Landscape Architect's response to Planning Application

From: Terra Firma Consultancy Ltd (Isla Denton-Thompson)

Application ref: BE/63/14/PL

Location: Manor Farm Shripney Lane Shripney

REV		DATE	COMMENTS	Date:	14.05.14	Status:	Planning
				Scale:	1 : 5000 @ A3	Project:	Manor Farm, Shipney
				Spec:	GRMS	Drawn:	Landscape Masterplan
				Check:	BR	Drawing Title:	
				Auth:	AH	Drawing No:	2563_101

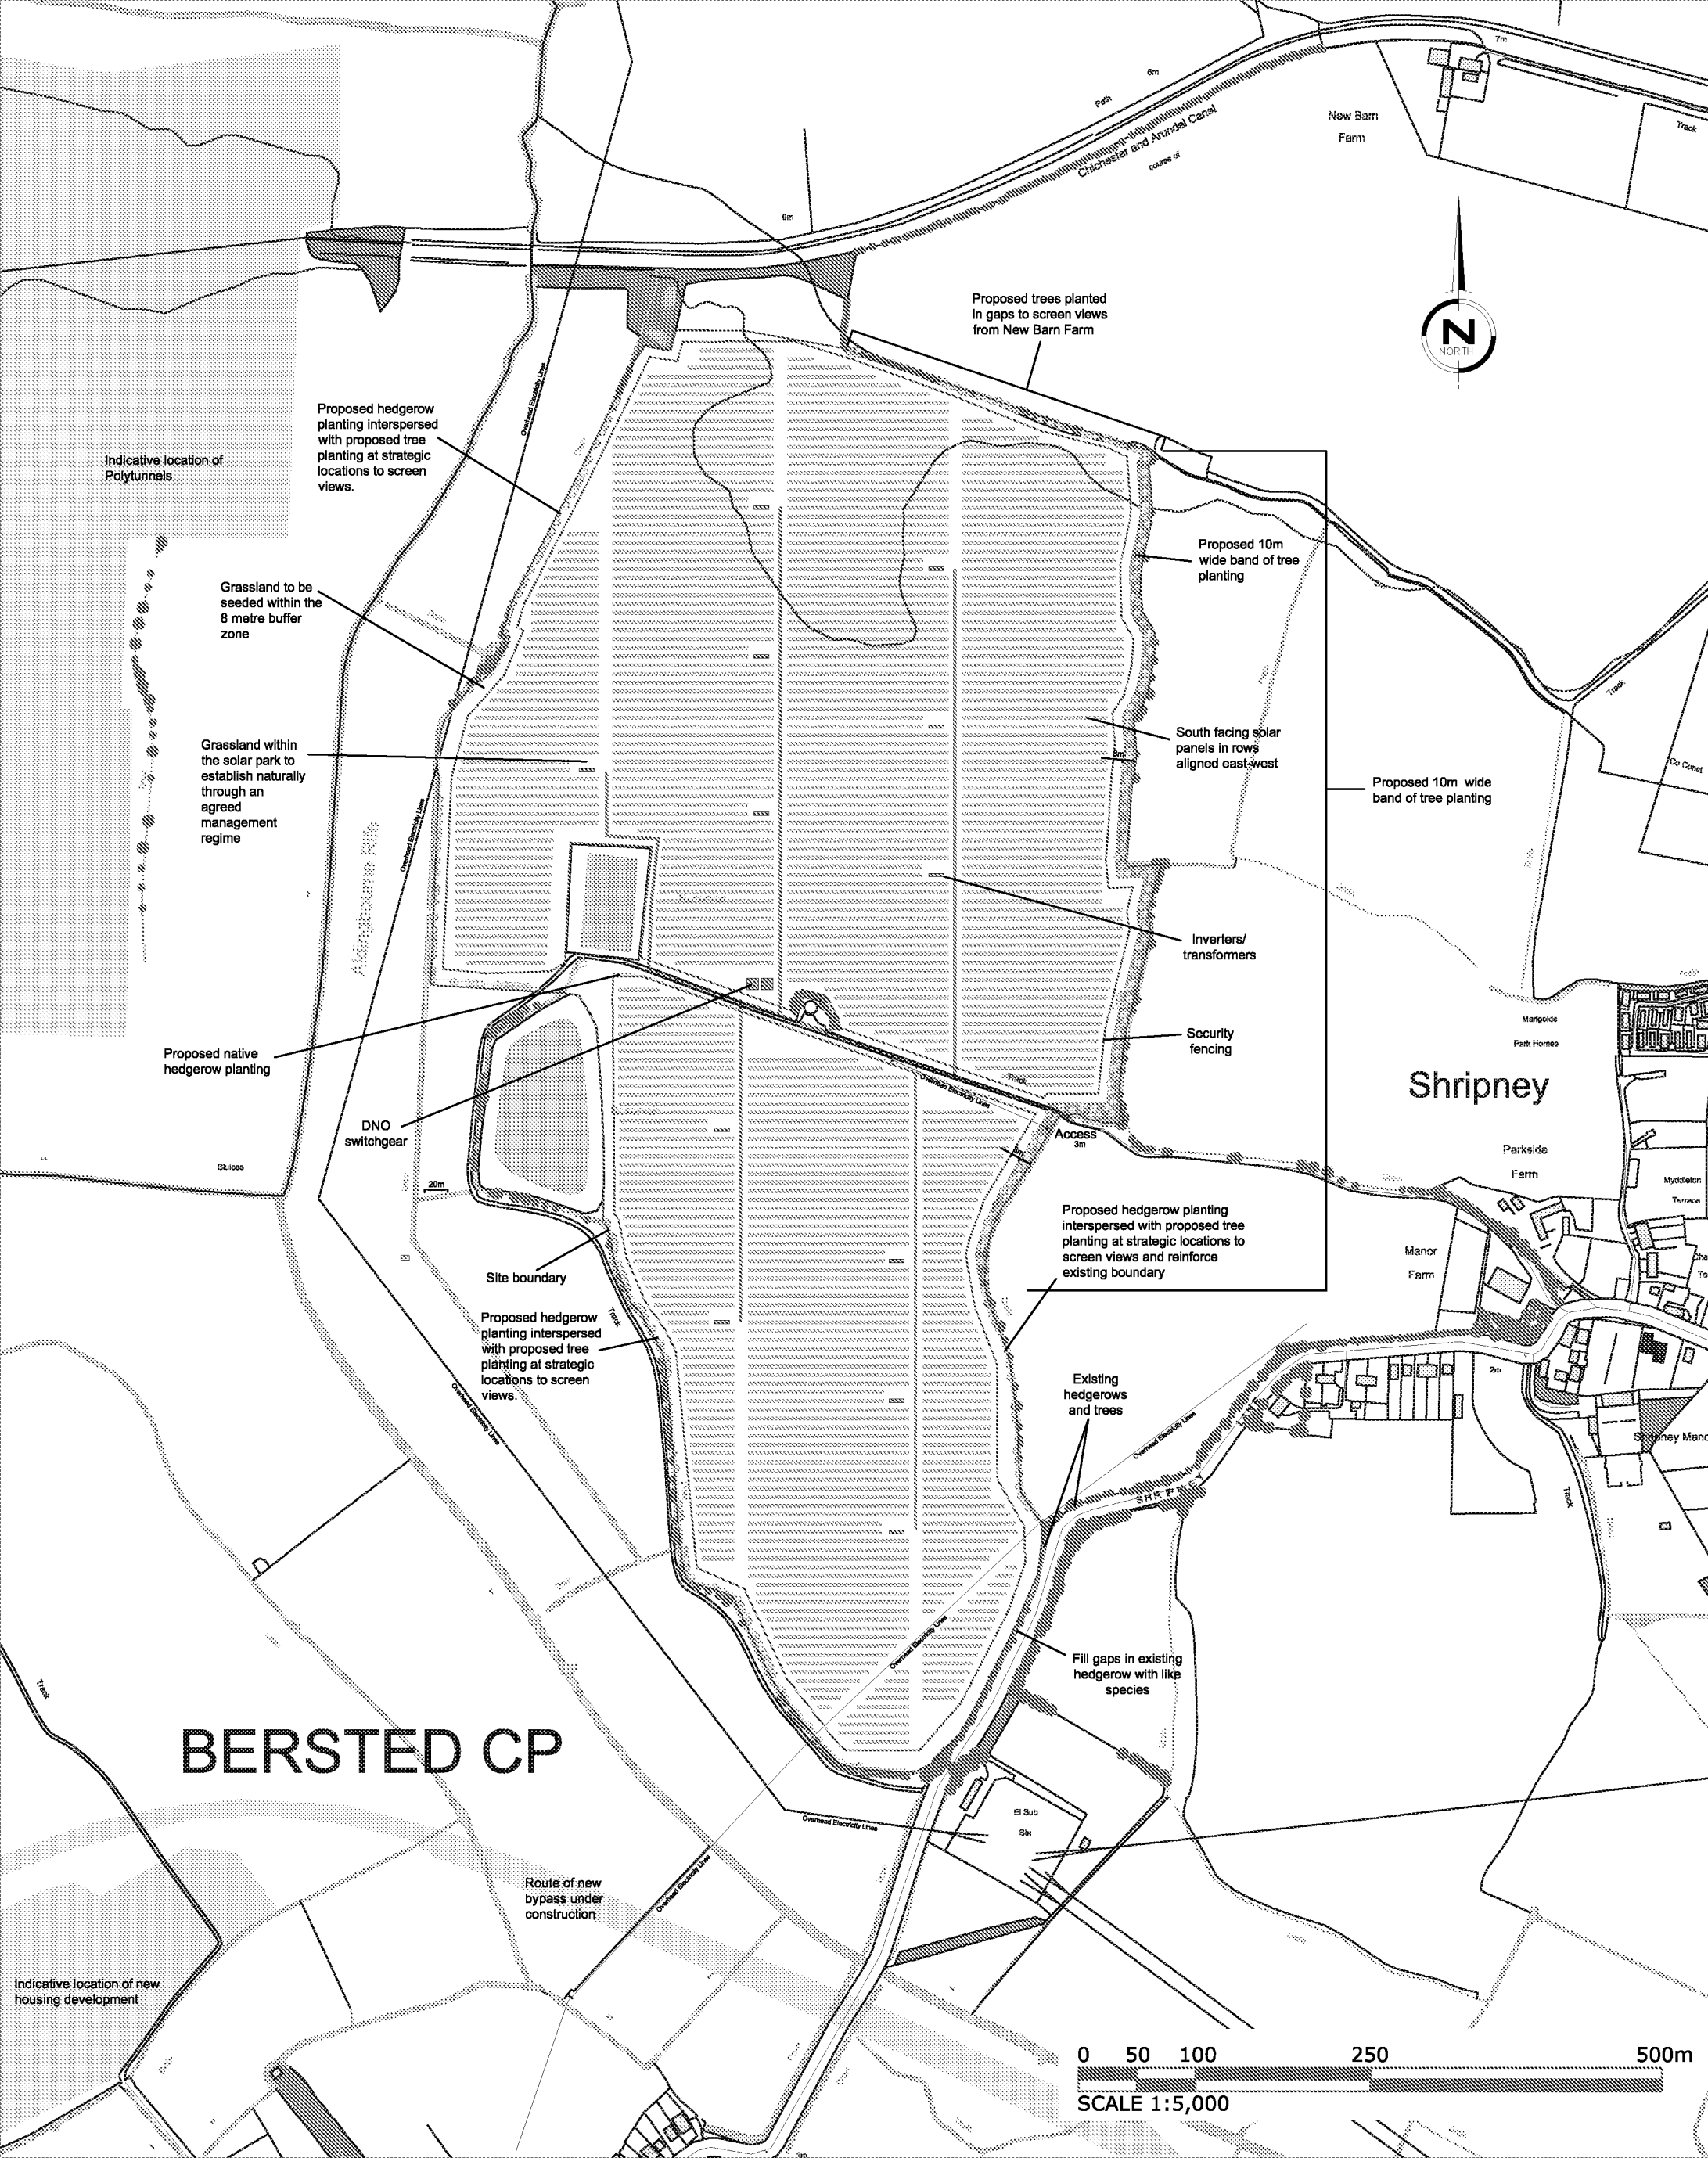
I agree with the findings of the applicants LVIA and the landscape mitigation measures it proposes. The combination of the proposed and existing vegetation will aid in integrating the proposed solar panels into the landscape and in largely screening potential views. However more information is required as to the exact location of proposed planting along the western site boundary.

I cannot find a plan which shows the route of the proposed underground cable connection to the substation. Confirmation should be provided that the route of the cable will not have an adverse impact on the existing trees. I also cannot find a plan showing the proposed location of the CCTV cameras. It is important that these are sympathetically integrated into the landscape, for example using existing/proposed trees as screening.

- More information is required as to the exact location of proposed planting along the western site boundary.
- The proposed location of the CCTV cameras should be confirmed. It is important that these are sympathetically integrated into the landscape, for example using existing/proposed trees as screening.
- I would advise that the natural fertility of the soil within the development area is safeguarded and enhanced for its future restoration back to agricultural land, particularly given that the land is classified as Grade 1 and 2 agricultural land.
- Full details and method statements for the planting and establishment of the proposed planting backed up with a management/maintenance plan should be conditioned including grazing/grassland management regimes.
